KIRKLEES METROPOLITAN COUNCIL INVESTMENT & REGENERATION SERVICE

DELEGATED DECISION TO DETERMINE APPLICATIONS FOR LISTED BUILDING CONSENT

Reference No:	2026/65/90665/W
Site Address:	65B, Westgate, Almondbury, Huddersfield, HD5 8XF
Description:	Listed Building Consent for alterations to convert garage to living accommodation to include new rooflight and window and amended window size (within a Conservation Area)
Recommending Officer:	Joanna Rednall

Officer Report

Proposed front/west facing elevation (1:100)

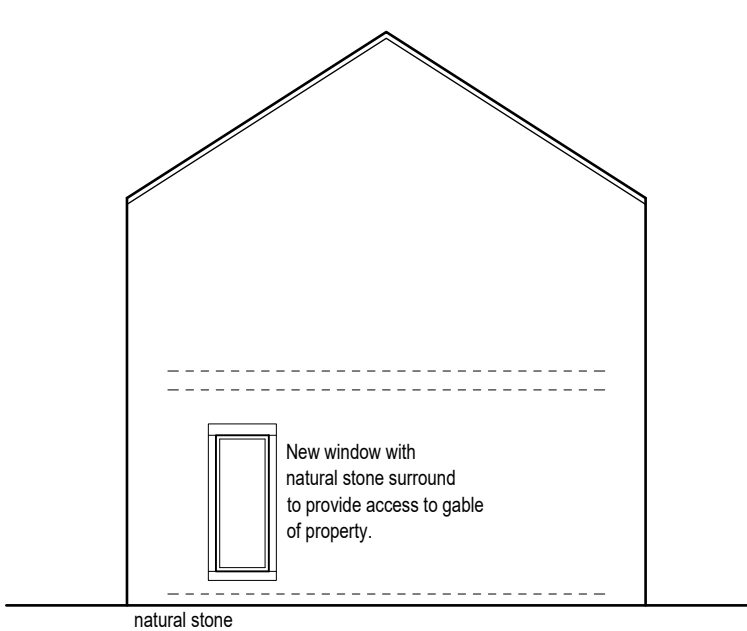
To the front elevation, both existing garage doors would be removed and replaced with a single window positioned within the former openings. The surrounding walling would be rebuilt in natural stone to match the existing building.

KC Conservation and Design were consulted on the proposal and initially raised concerns regarding the width of the proposed ground-floor windows, and officers advised that these openings should be reduced to better reflect the proportions of existing windows. Amended plans have since been submitted incorporating these changes, and the revised design now aligns more closely with the established character of the building. Given these amendments and considering the small-scale nature of the works, it is considered that the proposal would not result in harm to the significance of the listed building, subject to appropriate conditions.

The case officer sought amendments to reduce the size of the ground floor windows to align with existing first floor openings. Amended plans were submitted and the application has been progressed to determination on the basis of these.

Proposed side/west facing elevation (1:100)

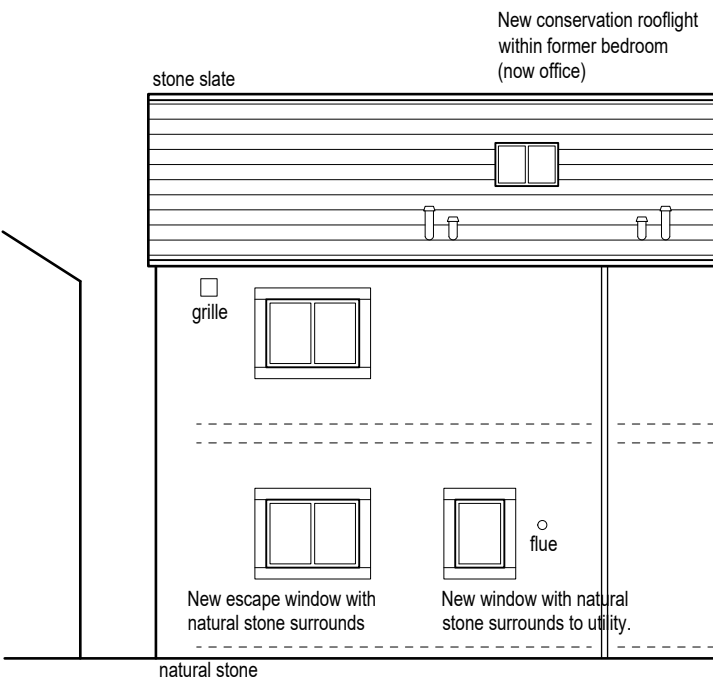
To the side (west-facing) elevation, one tall window is proposed.

On the side (west-facing) elevation, a tall window is proposed. This addition is modest in scale and has been positioned to increase natural light to internal rooms and to serve as an access point to the gable end of the property. Its placement and proportions ensure that it does not disrupt the architectural rhythm of the elevation.

Proposed rear/east facing elevation (1:100)

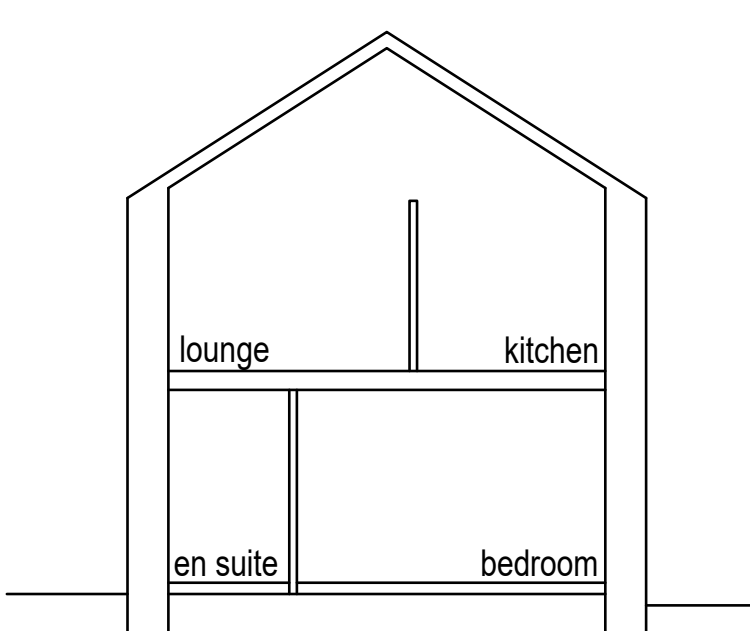
To the rear elevation, two new ground-floor windows are introduced along with a rooflight to provide additional natural light.

To the rear elevation, two new ground-floor windows and a rooflight are proposed. These elements are located on a less sensitive elevation and are intended to enhance internal amenity without altering the building's overall character. The submitted plans confirm that the rooflight would be of conservation style, which represents a more sensitive design approach. This ensures the rooflight sits discreetly within the roofscape and is therefore considered acceptable in heritage and visual terms.

Proposed ground floor layout (1:50)

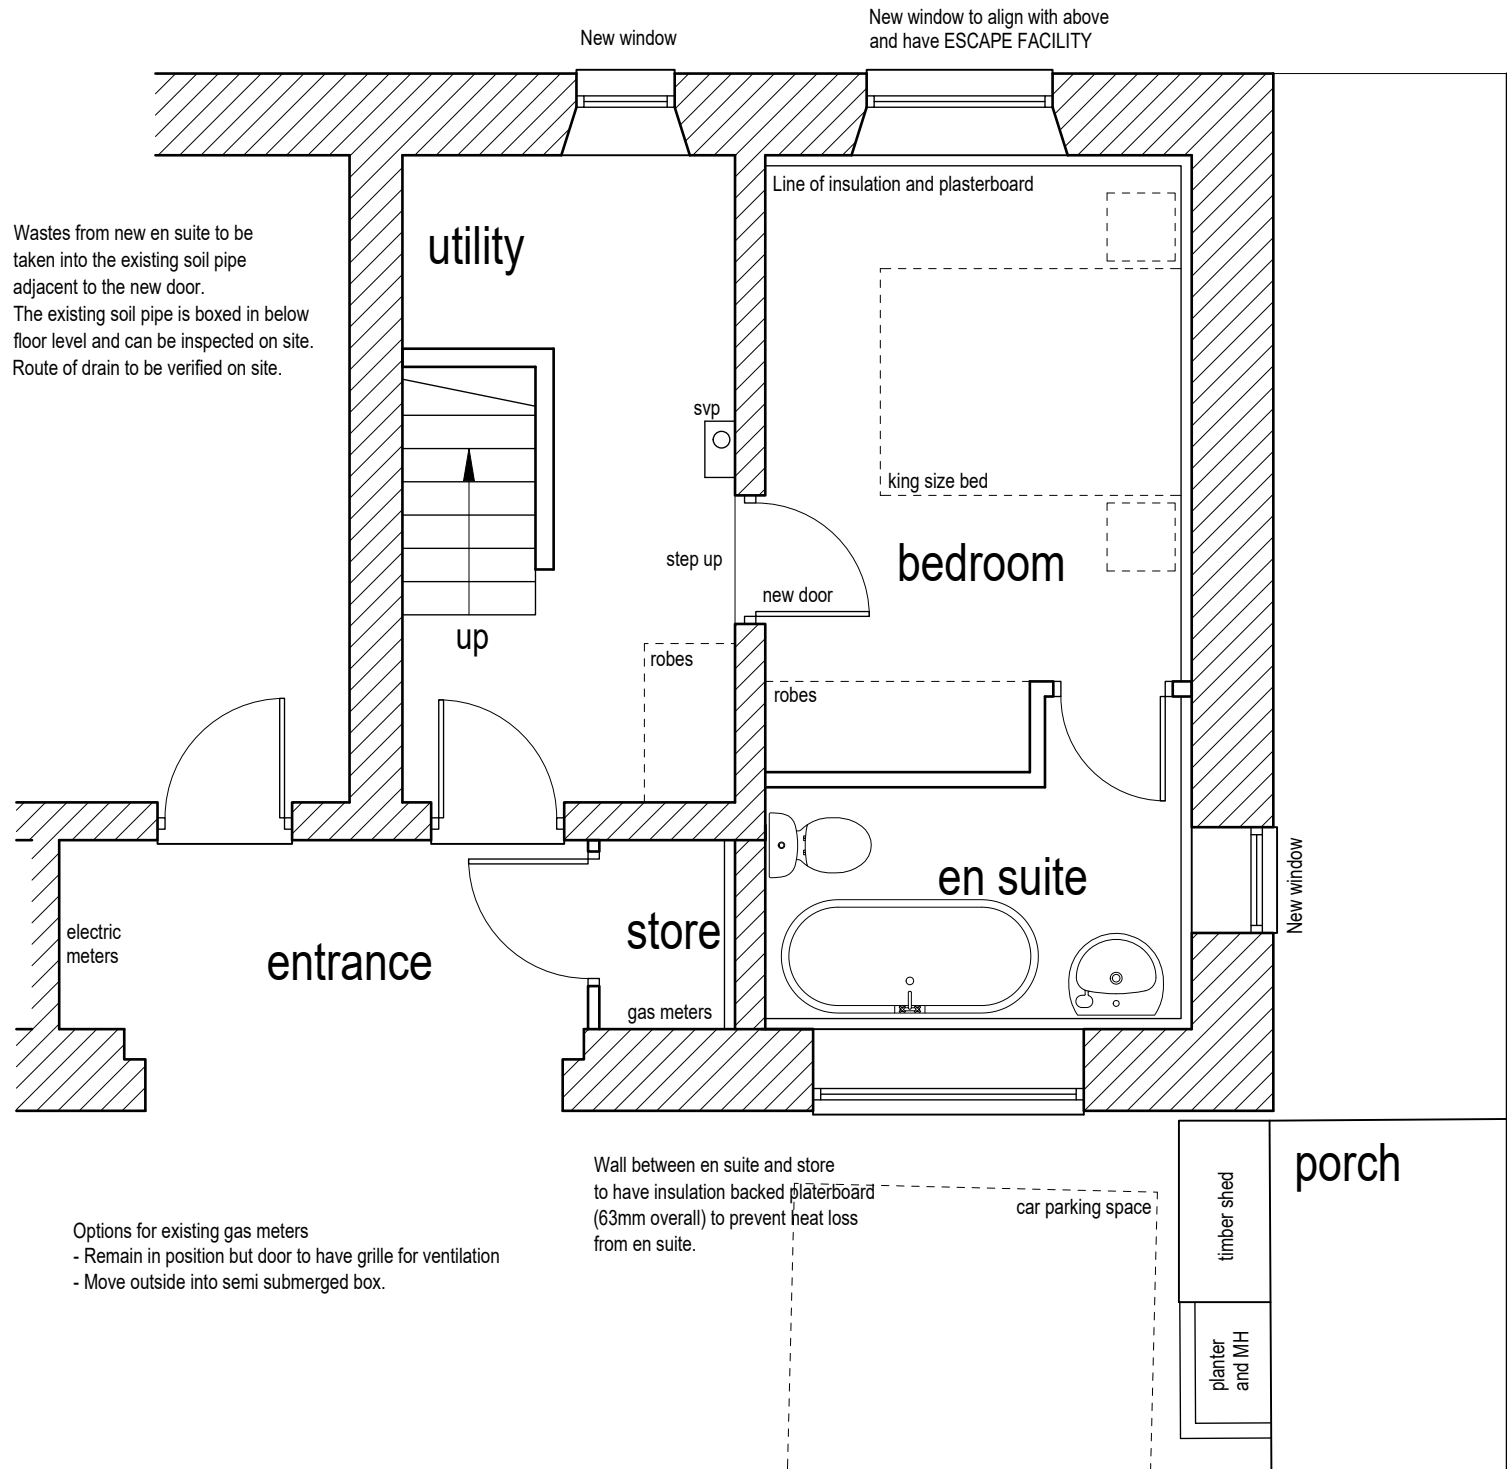
Internally, one new door is proposed to create a link between the bedroom and the utility room.

Internally, a single new door is proposed to create a link between the bedroom and the utility room. This is a minor, functional intervention that does not affect any significant historic fabric and remains fully reversible.
